CITY OF ALBUQUERQUE

Re: Glendale Development Lot 30 Grading and Drainage Plan
Engineer's Stamp dated 6-20-09 (B20/D20)

**Re: Glendale Development Lot 30-B Grading and Drainage Plan
Engineer's Stamp dated 8-8-09 (B20/D20)**

## GRADING & DRAINAGE PLAN

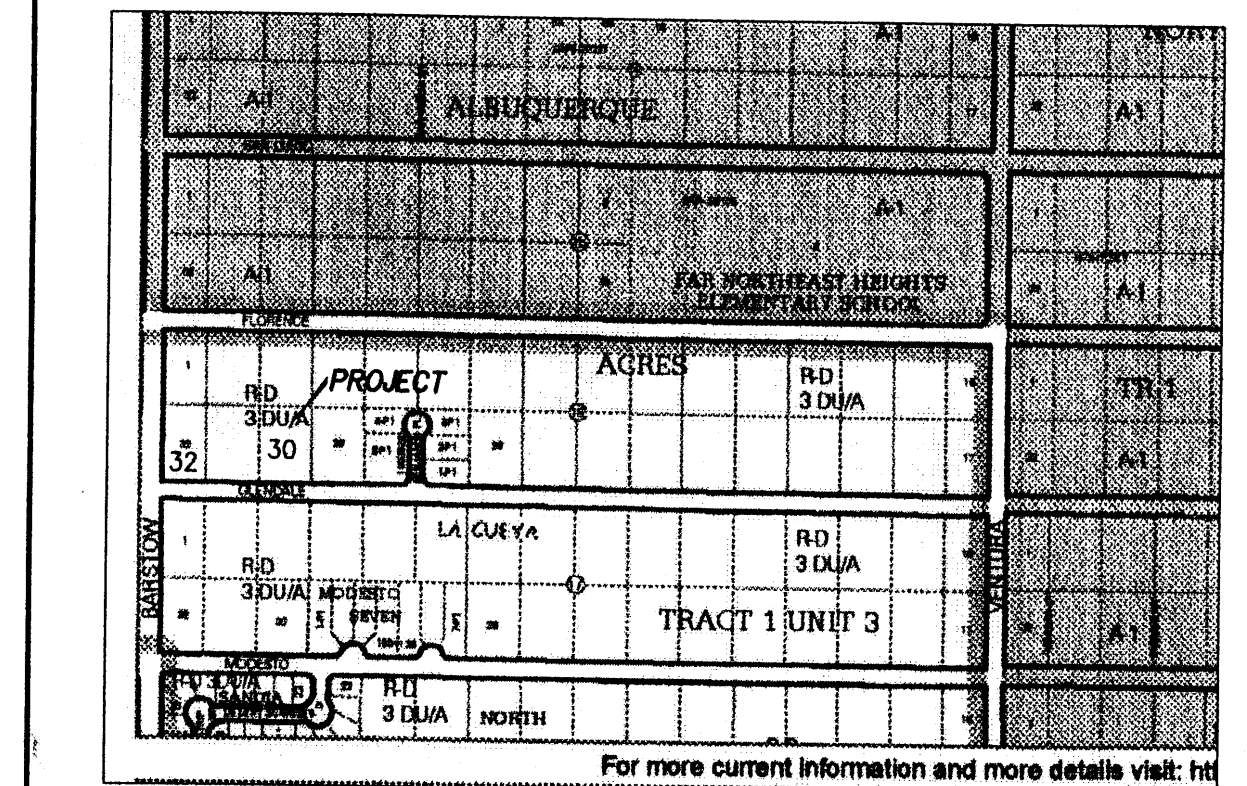
- Per the NAADMP, all developed runoff from this lot must drain to Glendale. Any change must address downstream capacity and all drainage easements must be provided.
- It appears that retaining wall must be built on both the east and west sides of this lot. Please provide all critical top-of-wall and bottom-of-wall elevations. It is especially important next to the existing block wall on the east side (which I will assume is not structural at all).
